*Proposed building
see more detailed document
below.*

The following needs to be added:

Basement - to be used for bed + breakfast

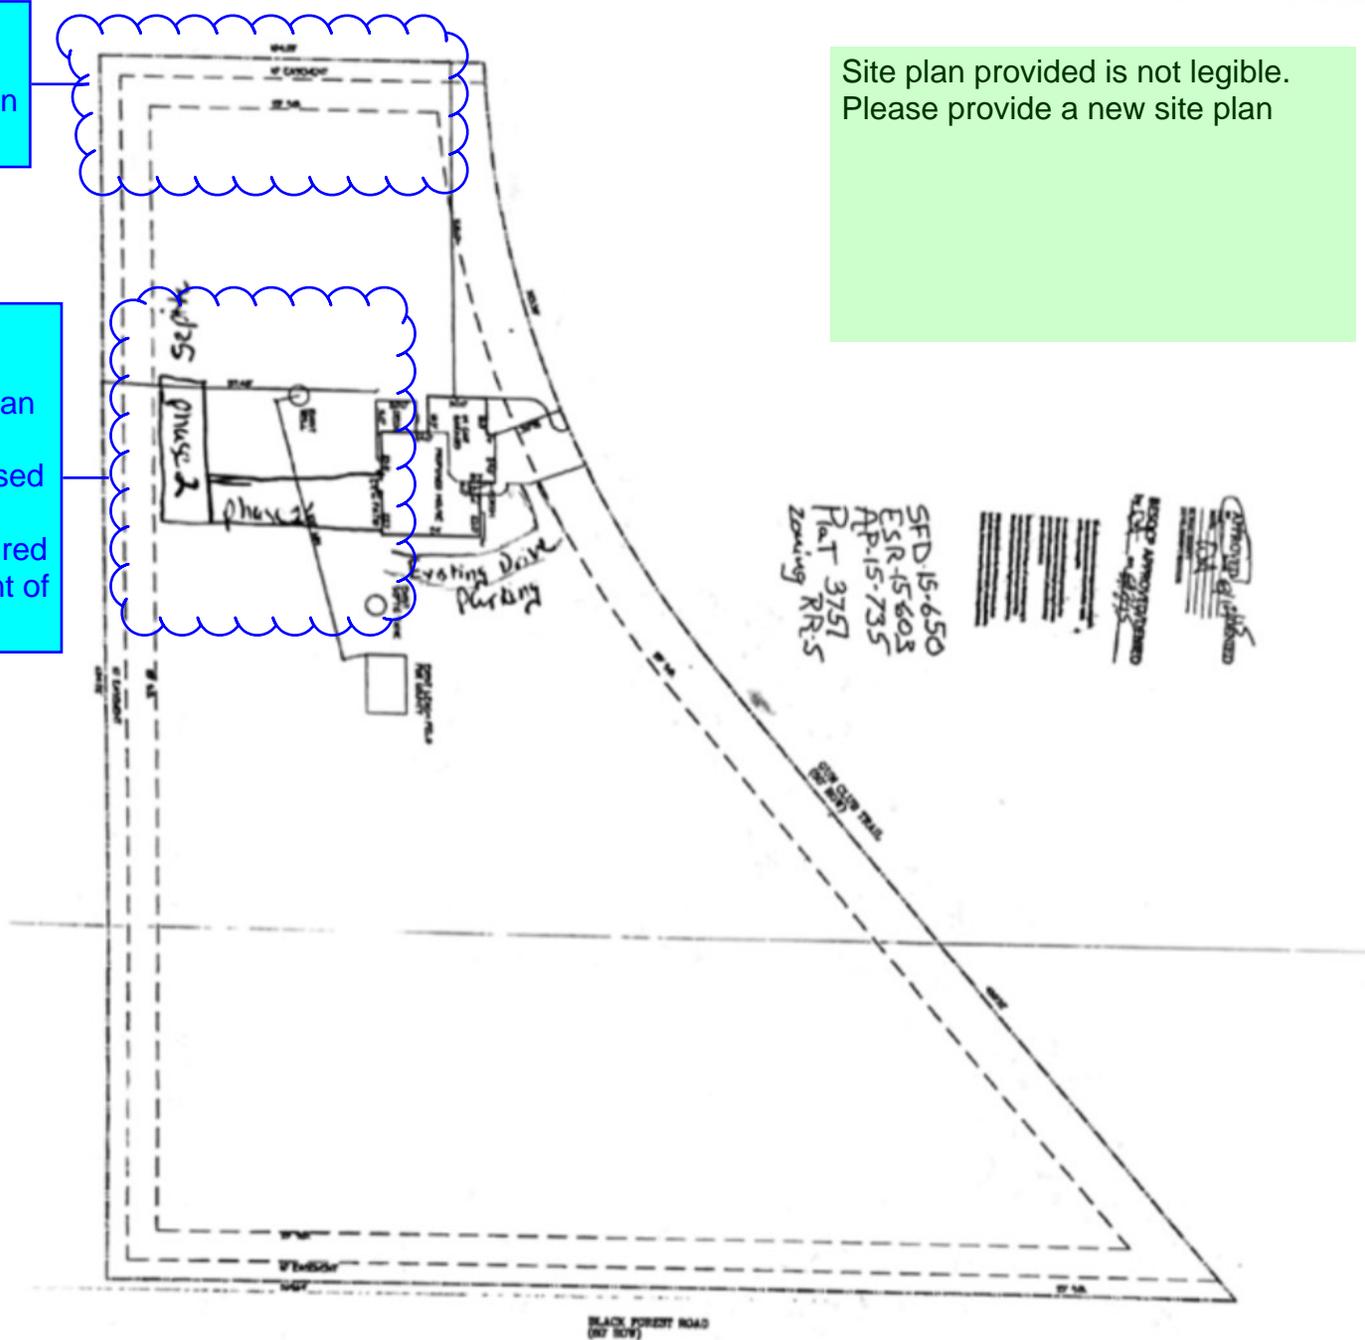
- Owner name, contact telephone number, and email for responsible party
- Property address
- Lot size
- Lot area coverage calculation
- Show required parking for bed and breakfast
